Current Zoning: R-3LWPA (single family residential, Lake Wylie Protected Area)  
Proposed Zoning: R-8MF(CD)LWPA (multi-family residential, conditional, Lake Wylie Protected Area)

Approximately 11.23 acres located at the southeast intersection of Oakdale Road and Mt. Holly-Huntersville Road, north of Interstate 485

The petition proposes to redevelop 4 large single family lots with up to 88 single family attached units as a second phase of development approved for the adjacent site to the east in northwest Charlotte.

REZONING PETITION #2022-170
SCHEMATIC SITE PLAN

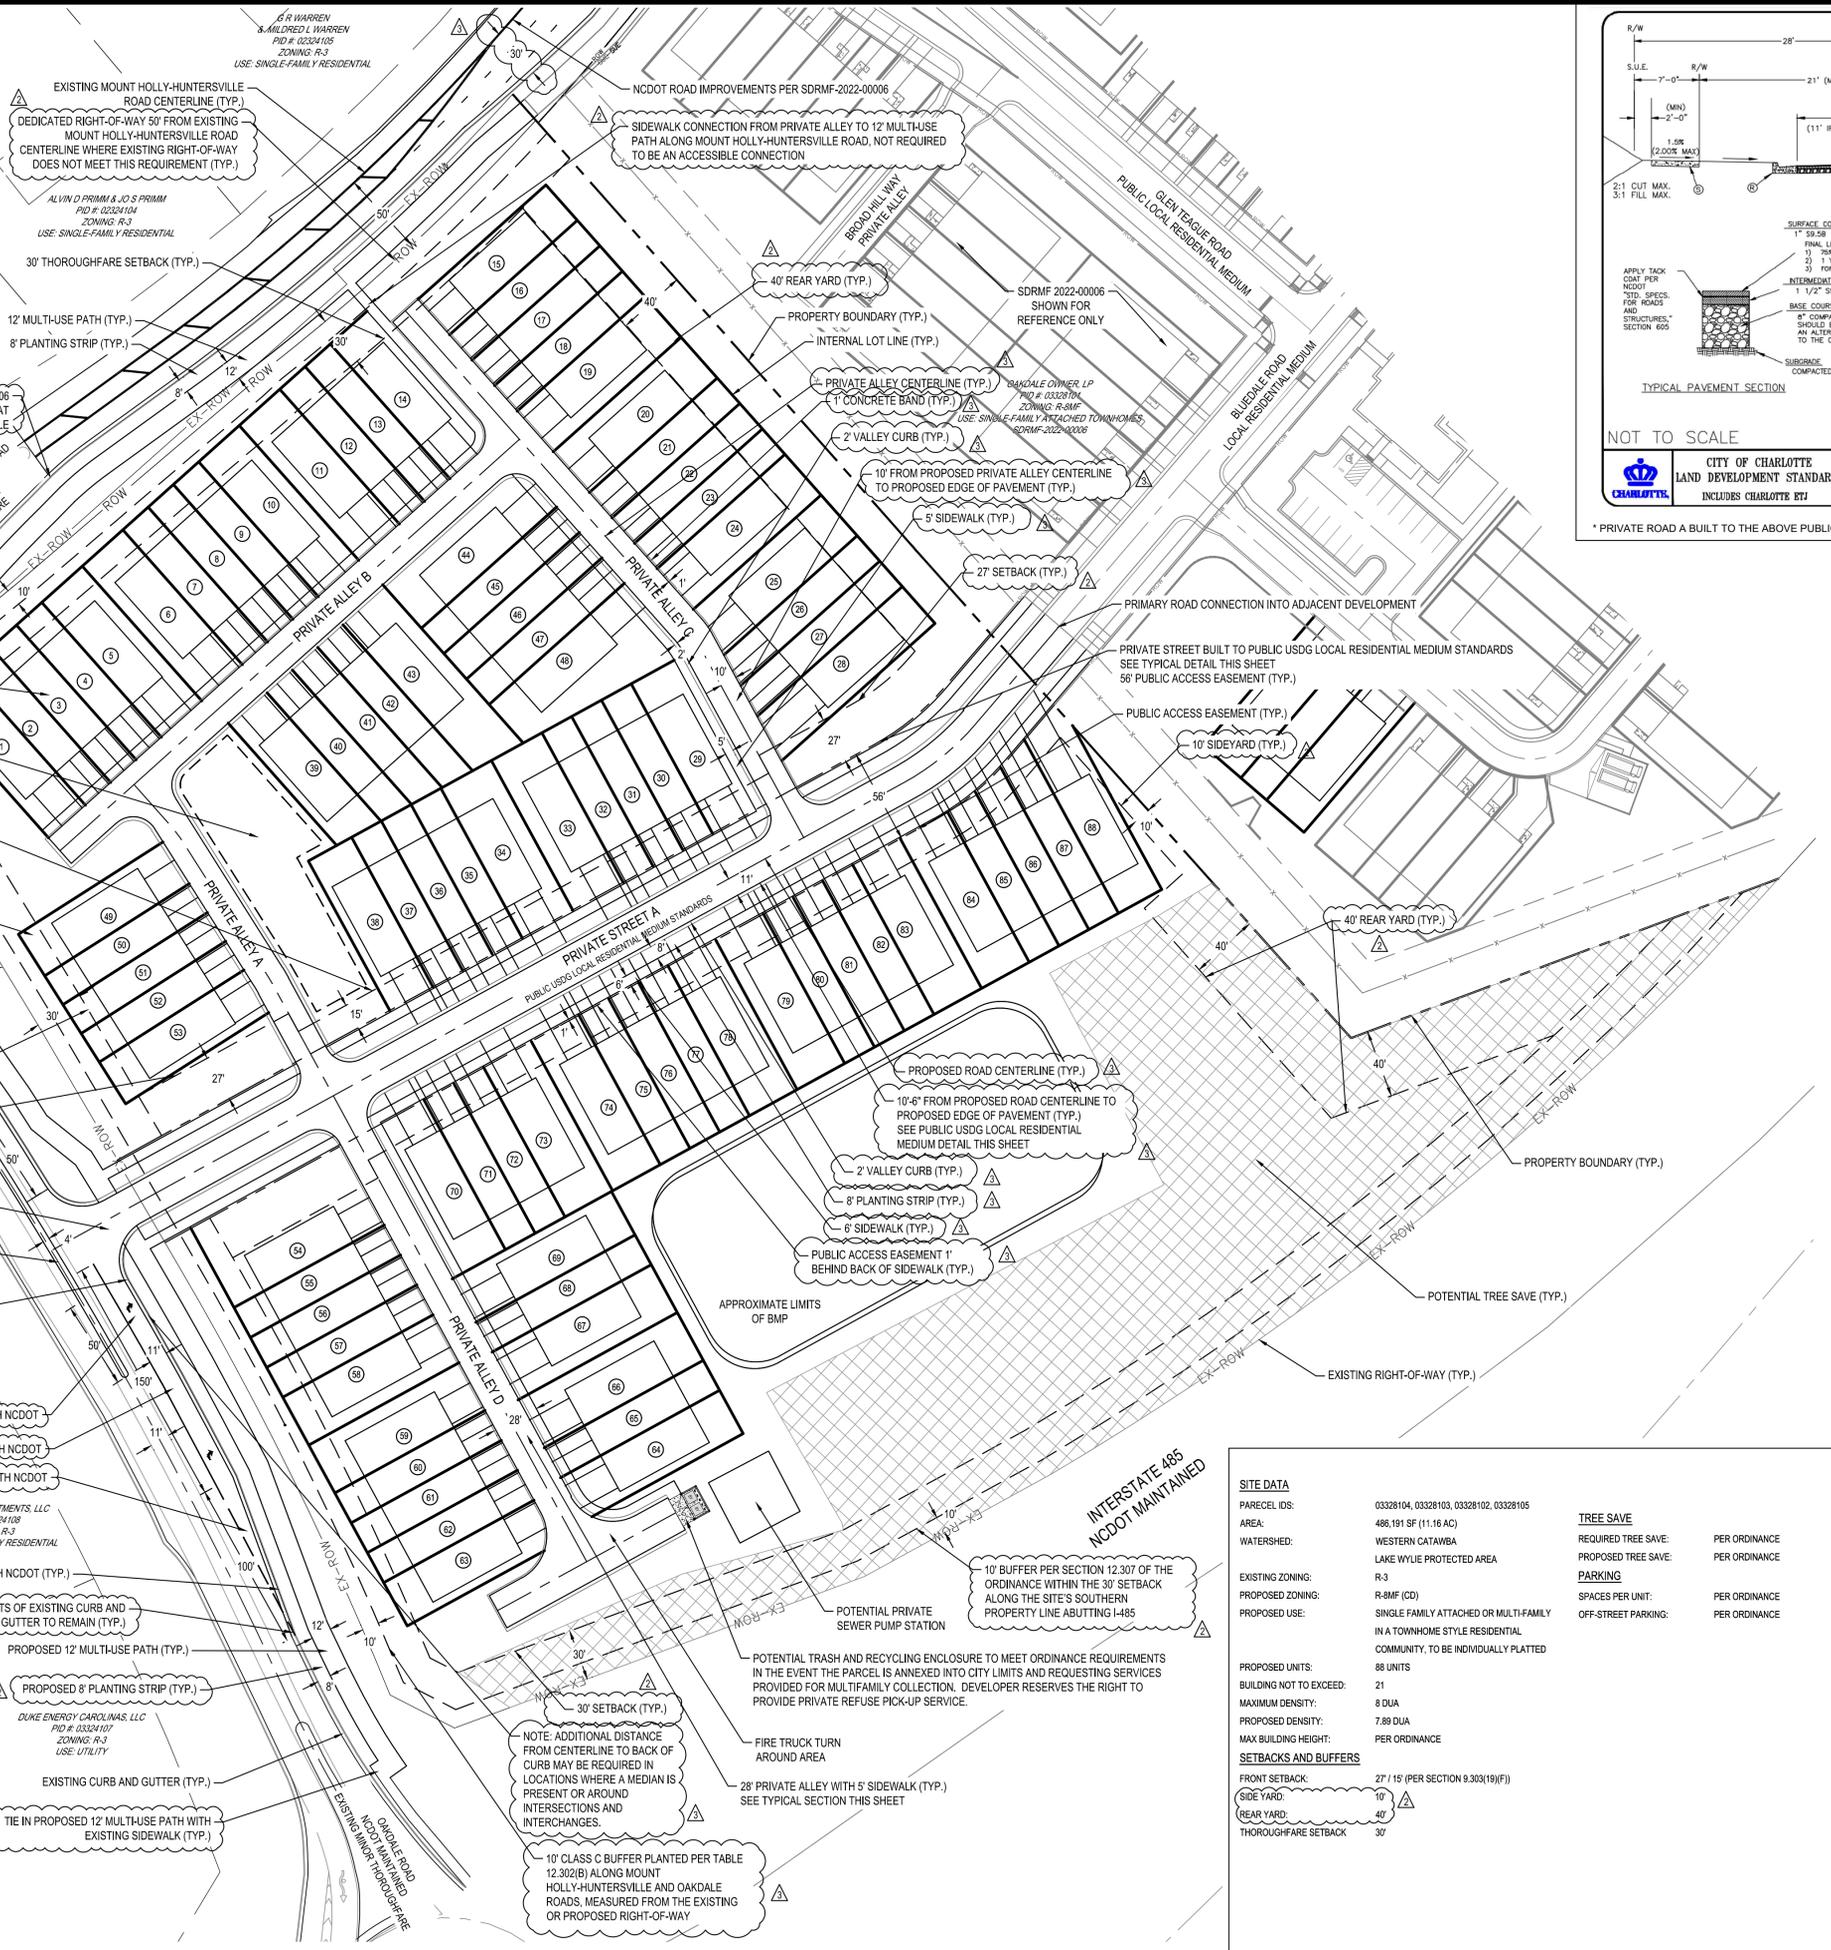
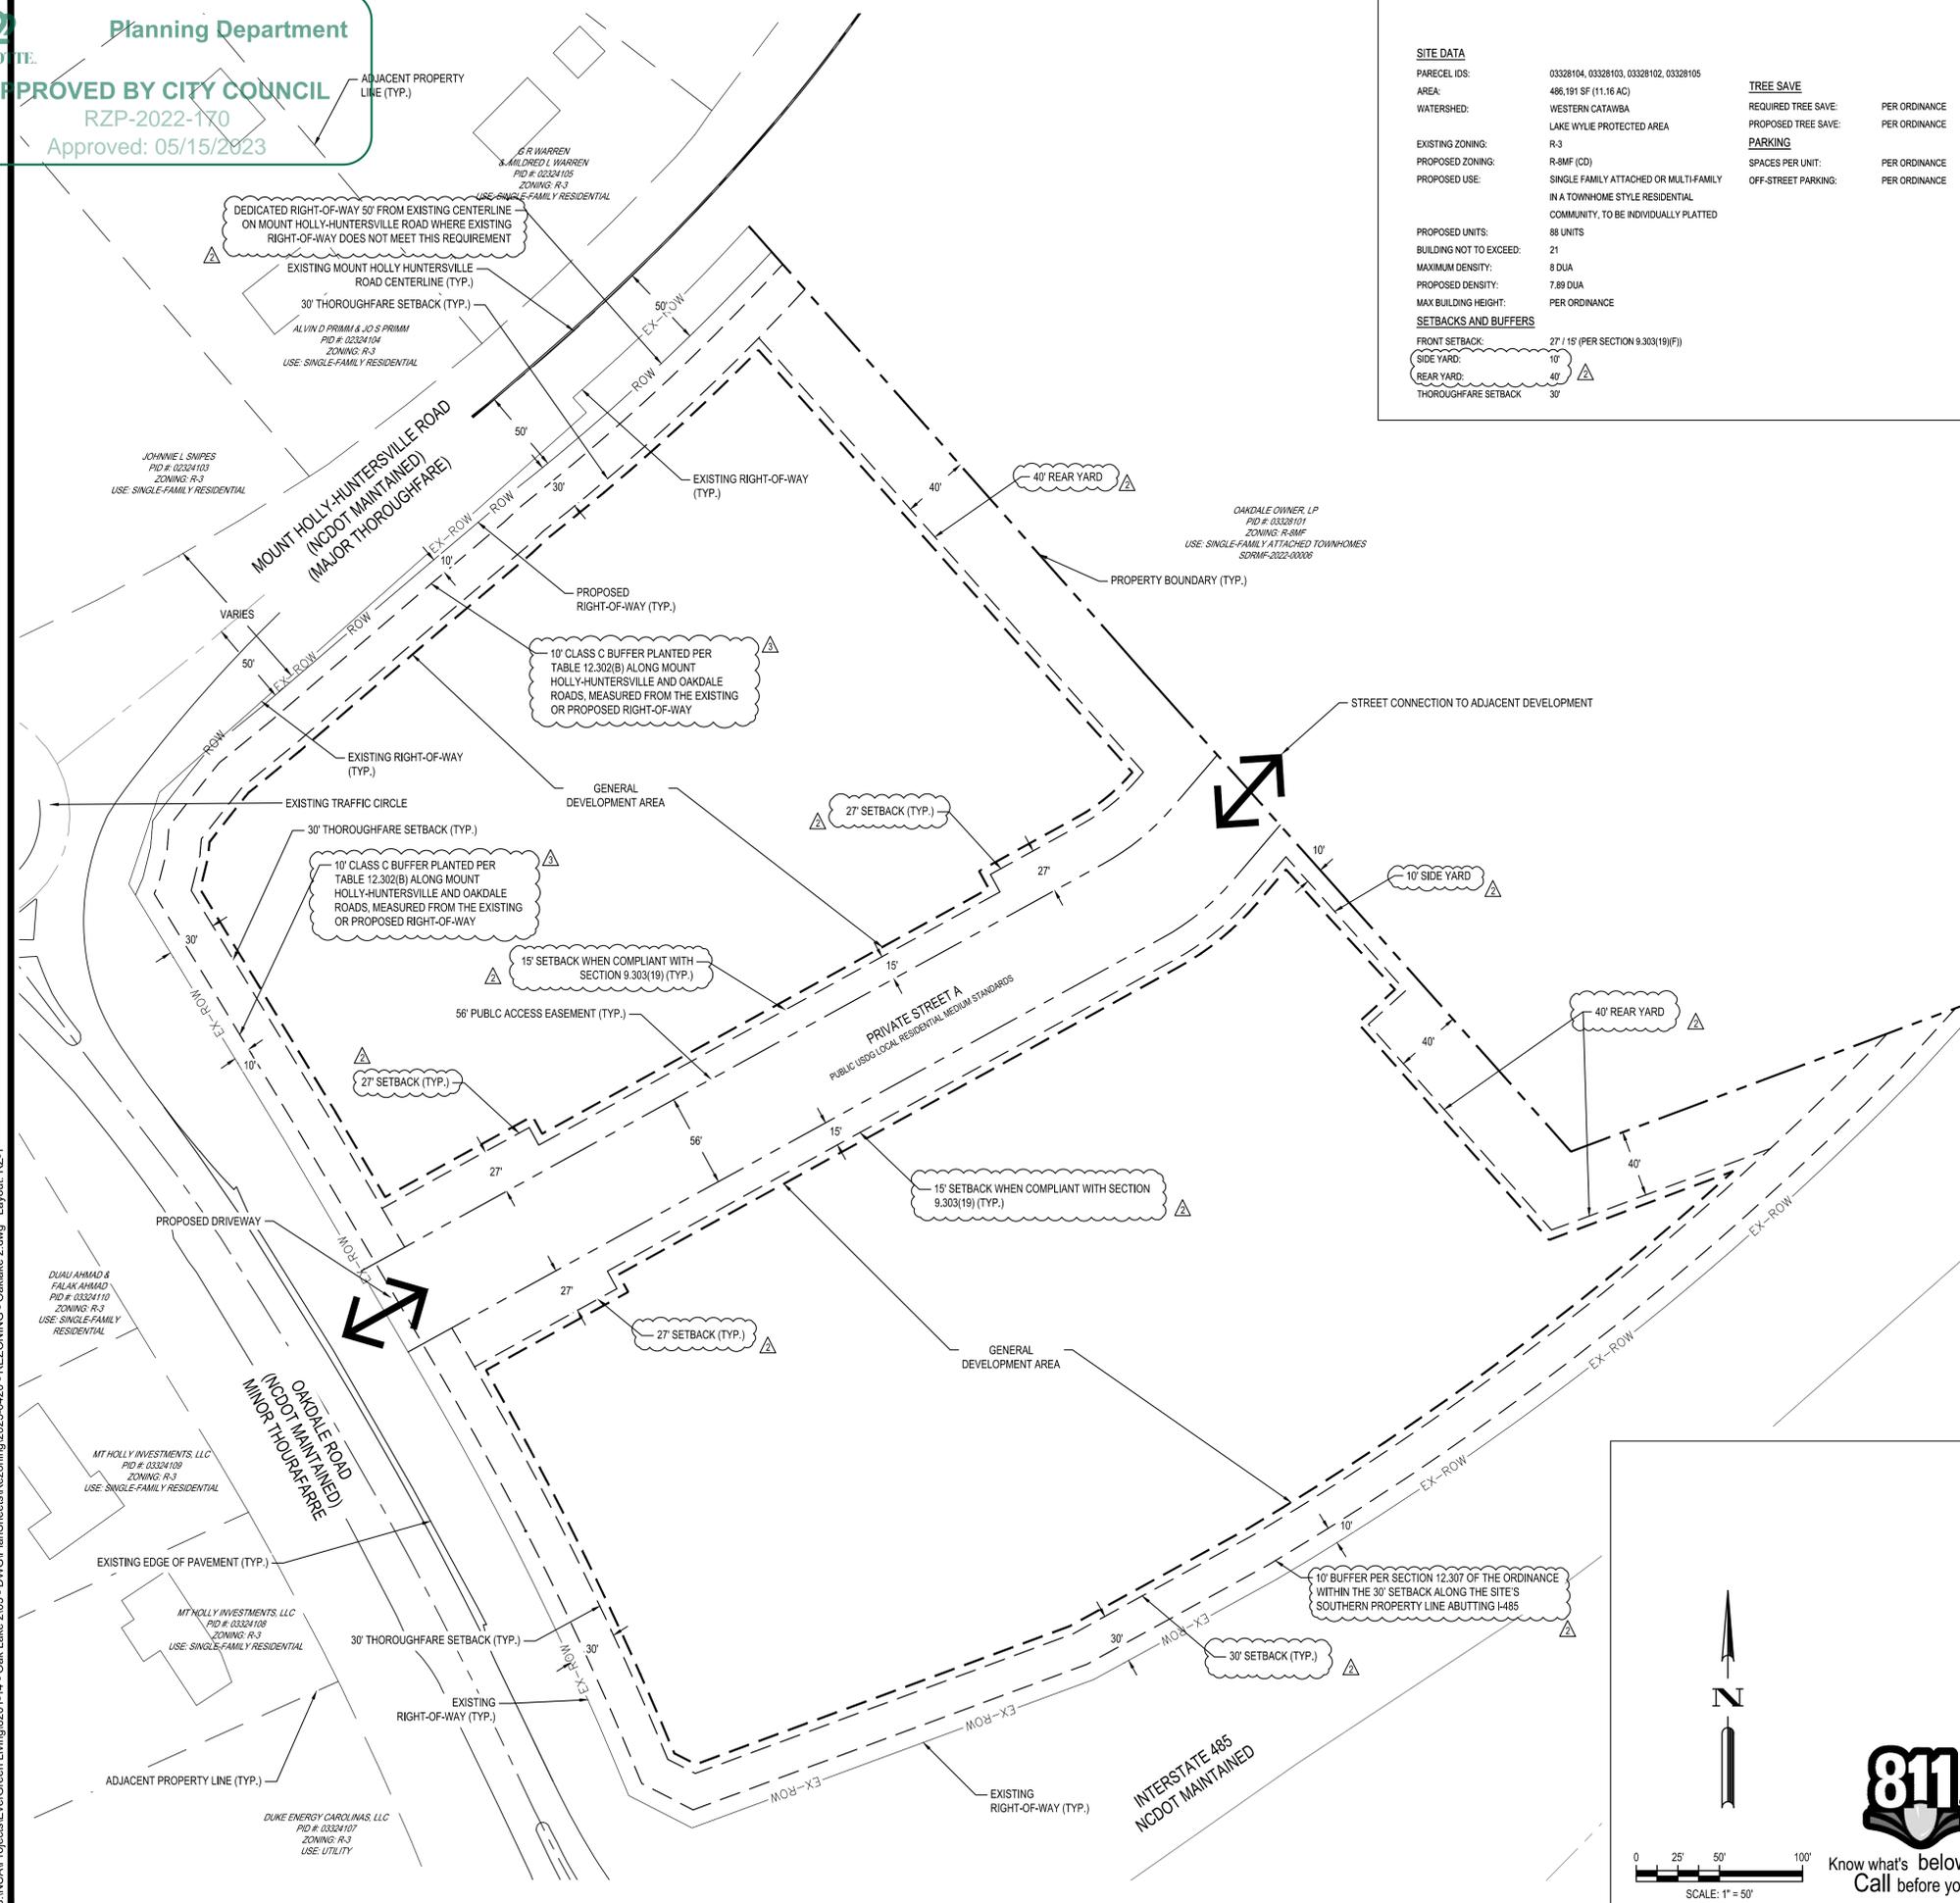
1. Add provision for landscaping including trees and shrubs along the frontages of Mt Holly-Huntersville Rd and Oakdale Rd.
2. Revise Architectural Standard note F. related to visual impact of garage doors by making Porch/stoops a part of every unit and its own individual note. And remove iv. related to windows above or beside the garage door.
3. Remove strike throughs from development standards on the site plan.
4. Commit to a total minimum area for the amenity area(s).

5. Label and dimension the curb and gutter from the centerline for each road on the site plan.
6. Location of curb and gutter along Mt. Holly-Huntersville Rd. to be moved 30 ft from roadway centerline to accommodate Charlotte Streets Map with a section of 4+ Avenue and shared use path.

7. Label and dimension internal street infrastructure including curb line, sidewalks, plantings strips and right-of-way.
8. Add a conditional note specifying "A Right-of-Way Encroachment Agreement is required for the installation of any non-standard item(s) (irrigation systems, decorative concrete pavement, brick pavers, etc.) within a proposed/existing city-maintained street right-of-way by a private individual, group, business, or homeowner's/business association. An encroachment agreement must be approved by CDOT prior to construction/installation. Contact CDOT for additional information concerning cost, submittal, and liability insurance coverage requirements."

11. Remove driveways from CDOT 50'x50' sight triangles areas connecting to Street A.
